Re: Objection to MP08_0244 MOD 1 Modification Request for Mixed Used Development at 23-37 Lindfield Avenue and 11 Havilah Lane, Lindfield

1 HAVILAH LA ELEVATION
2001 SCALE1 : 250

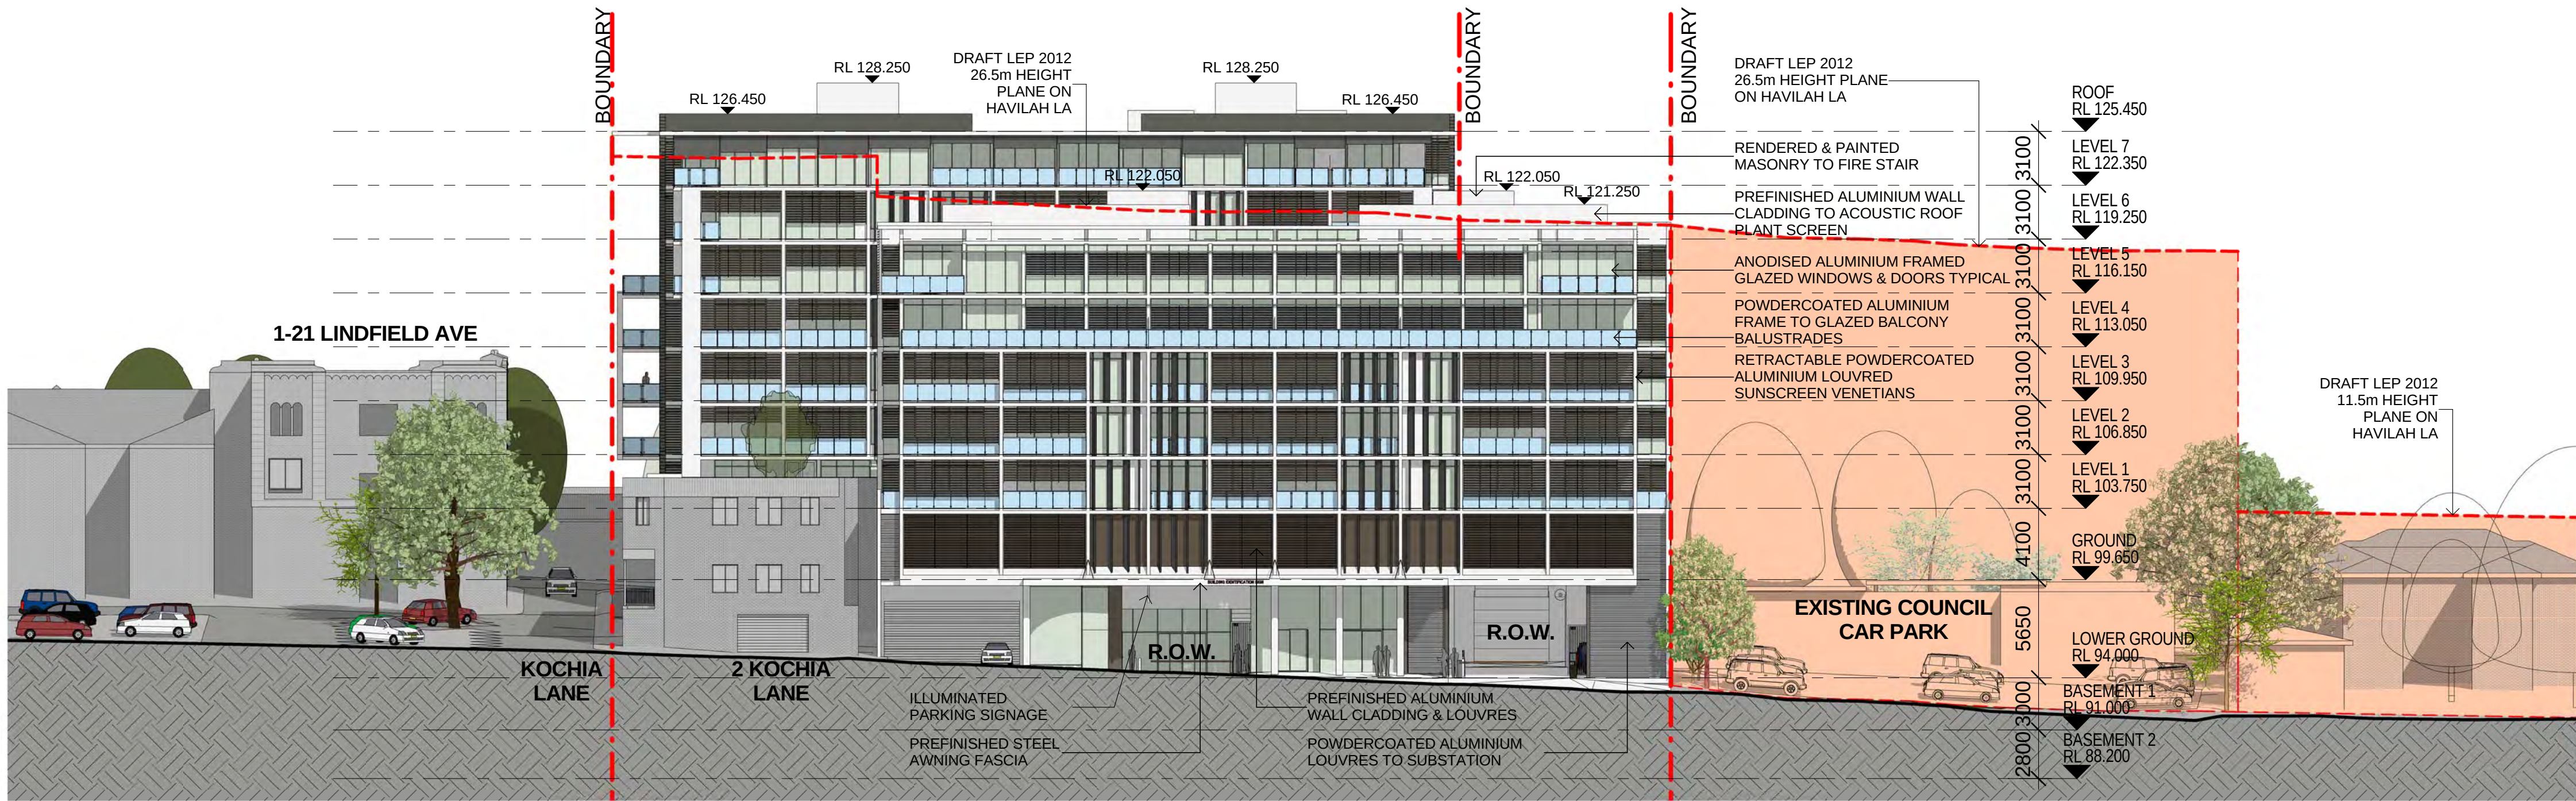
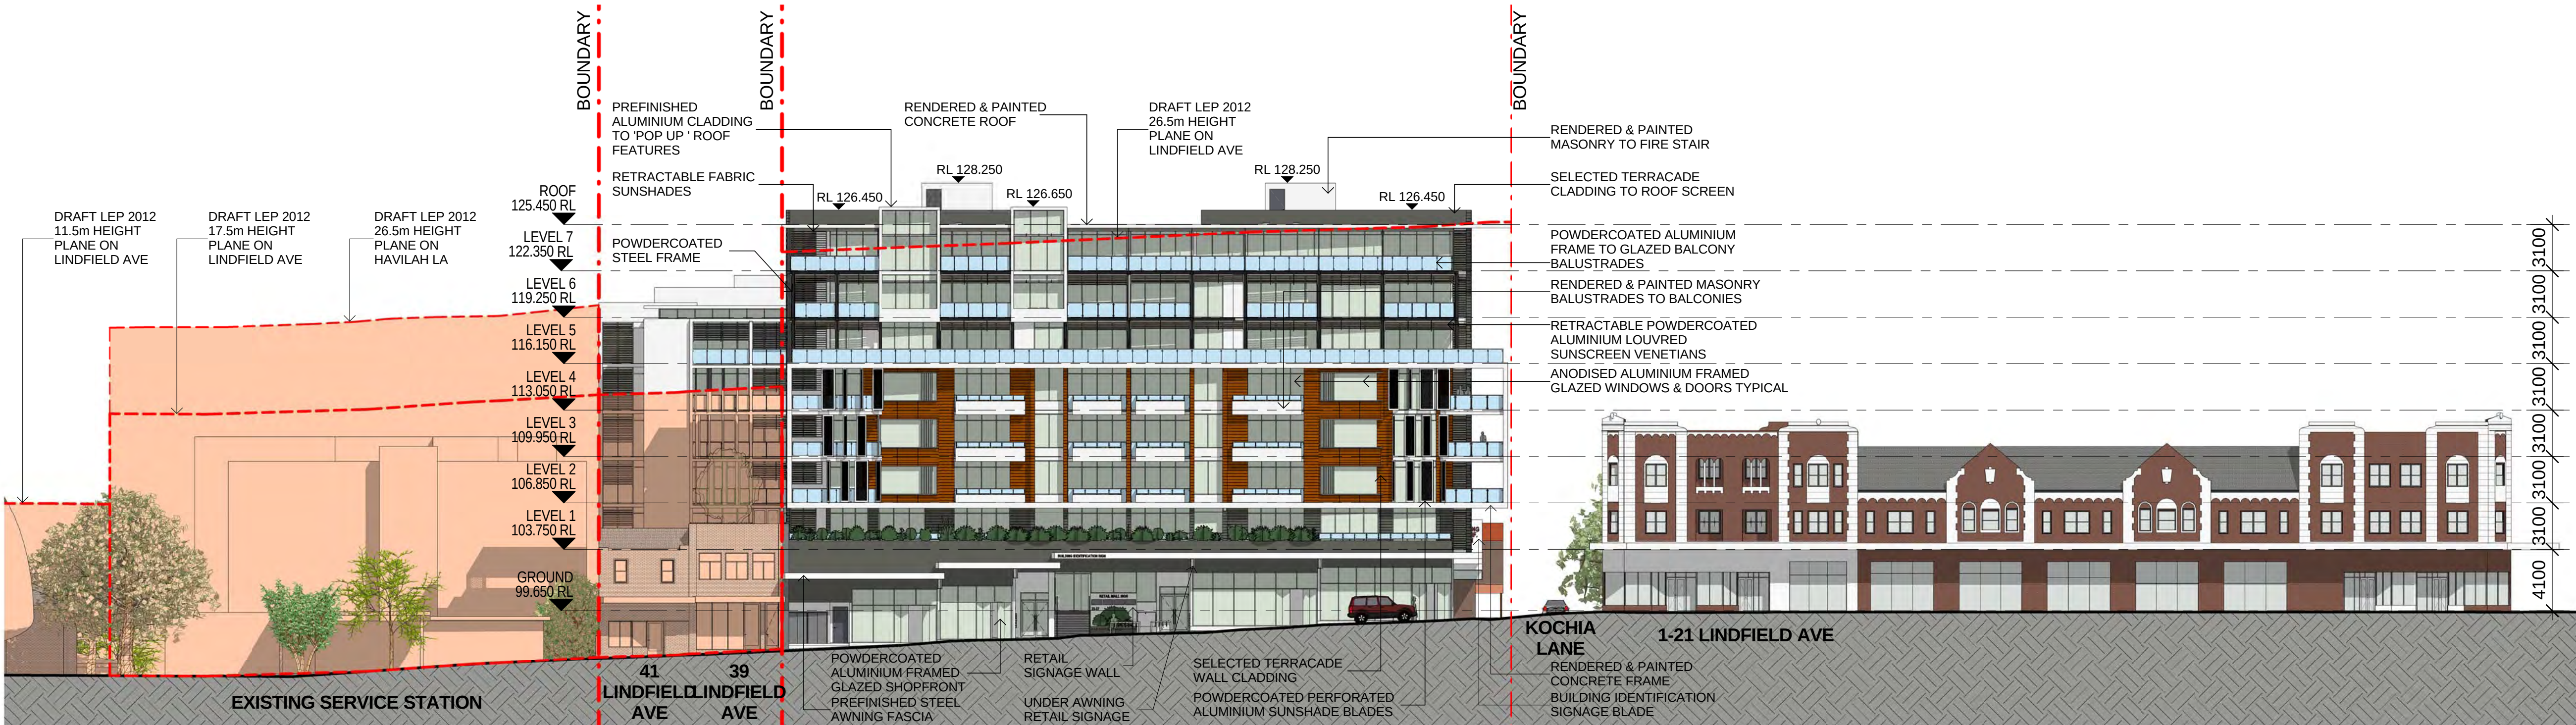
- The increase of an additional storey to both buildings: 8 storeys on Lindfield Avenue and 7 storeys on Havilah Lane creates excessive height and bulk and is out of character with the surrounding buildings, including the heritage listed adjacent building on Lindfield Avenue

- The additional storey (combined with less set back than the approved design) on Havilah Lane now creates privacy concerns for over 40 apartments in the adjacent 8 Havilah Lane, 8 Kochia Lane and 2-8 Milray Street residences
